12 October 2022

TfNSW Reference: SYD20/01146/08
Departments Reference SSD-9794683

**MODIFICATION AMENDED PLANS FOR OAKDALE WEST ESTATE STAGE 3 - WAREHOUSES 2A, 2C, 2D, 2E - 2
- 18 ALDINGTON ROAD, KEMPS CREEK**

Figure 5 | Proposed Warehouses 2C and 2D Plan

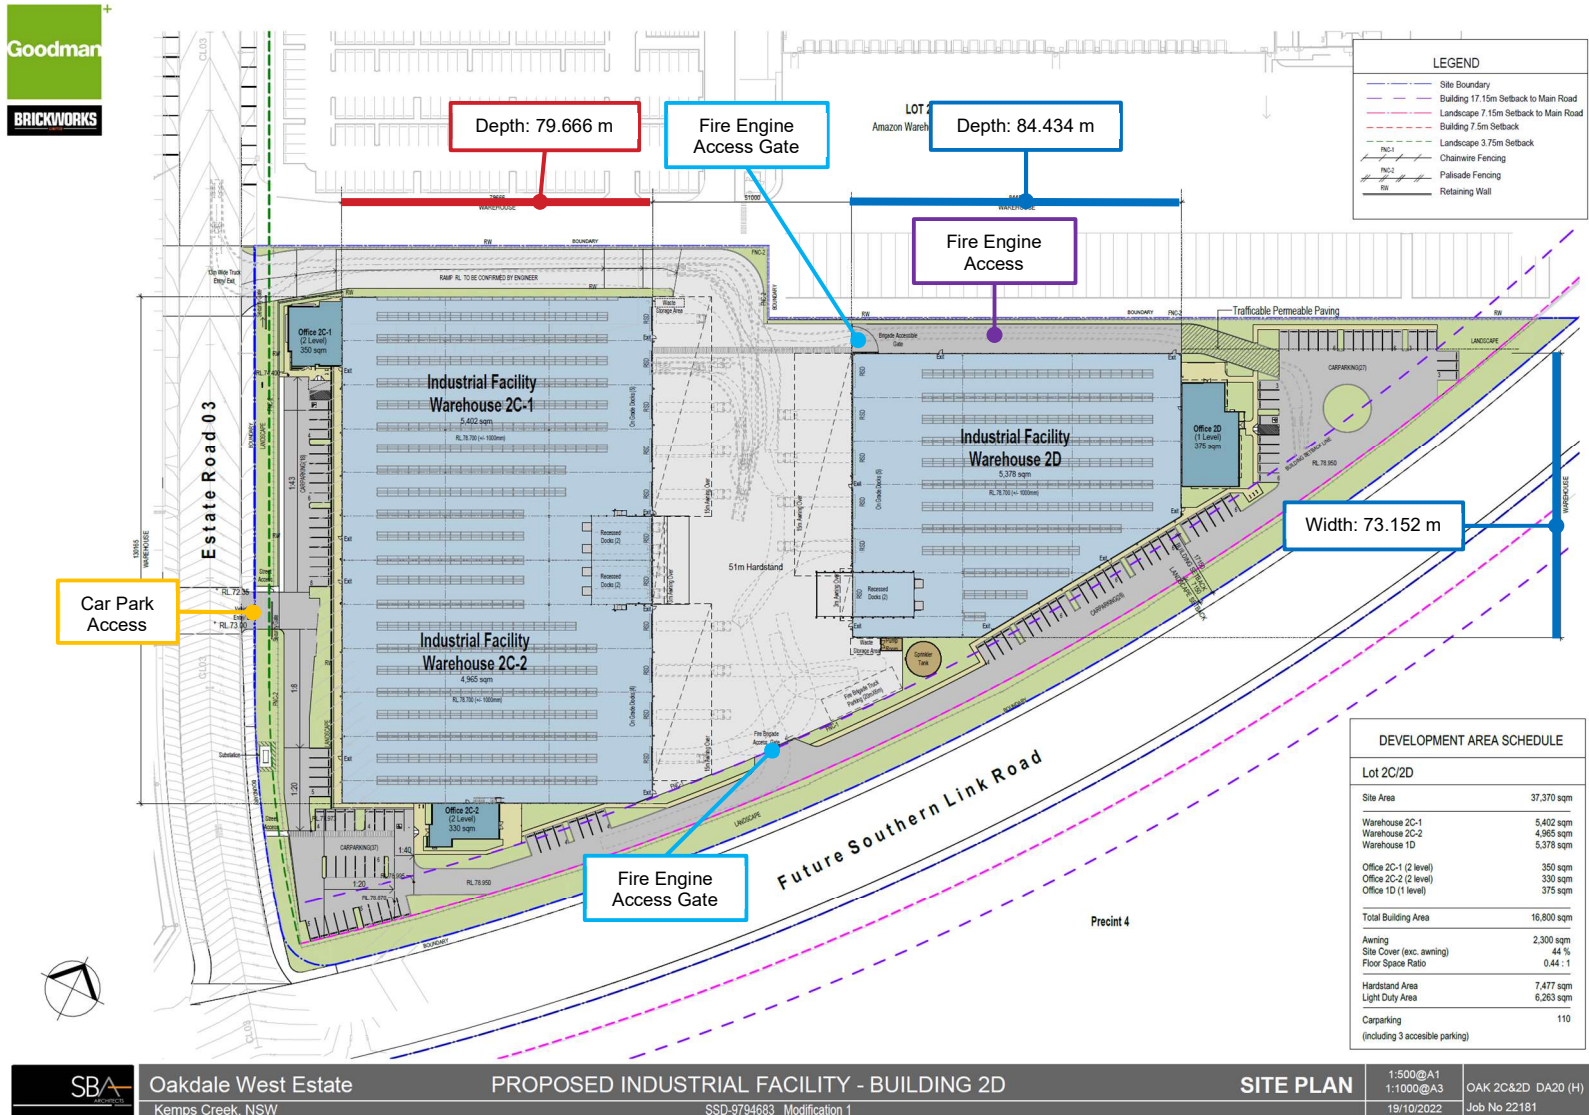
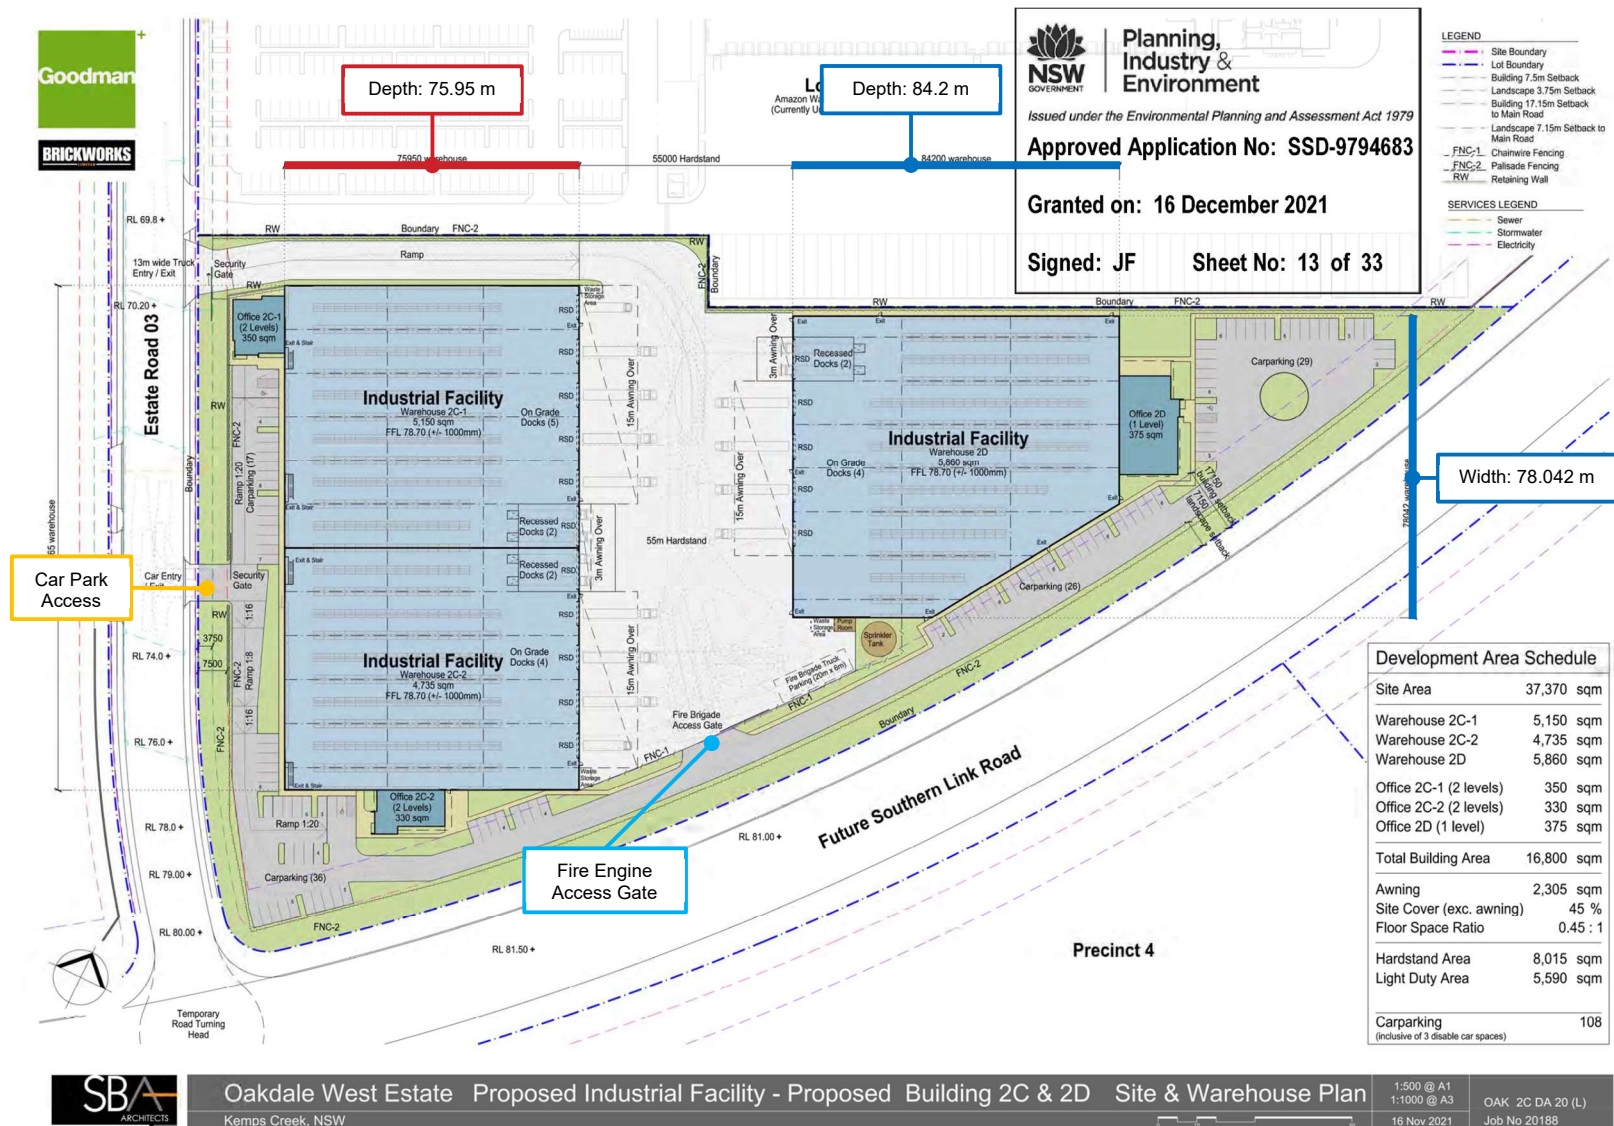
As advised previously in our correspondence 20 November 2021, TfNSW raised concerns regarding the proximity of the building 2C-2 car entry access to the proposed signalised intersection at the future Southern Link Road (SLR). TfNSW does not support the modification to position the driveway a further 31 metres closer to the Southern Link Road.
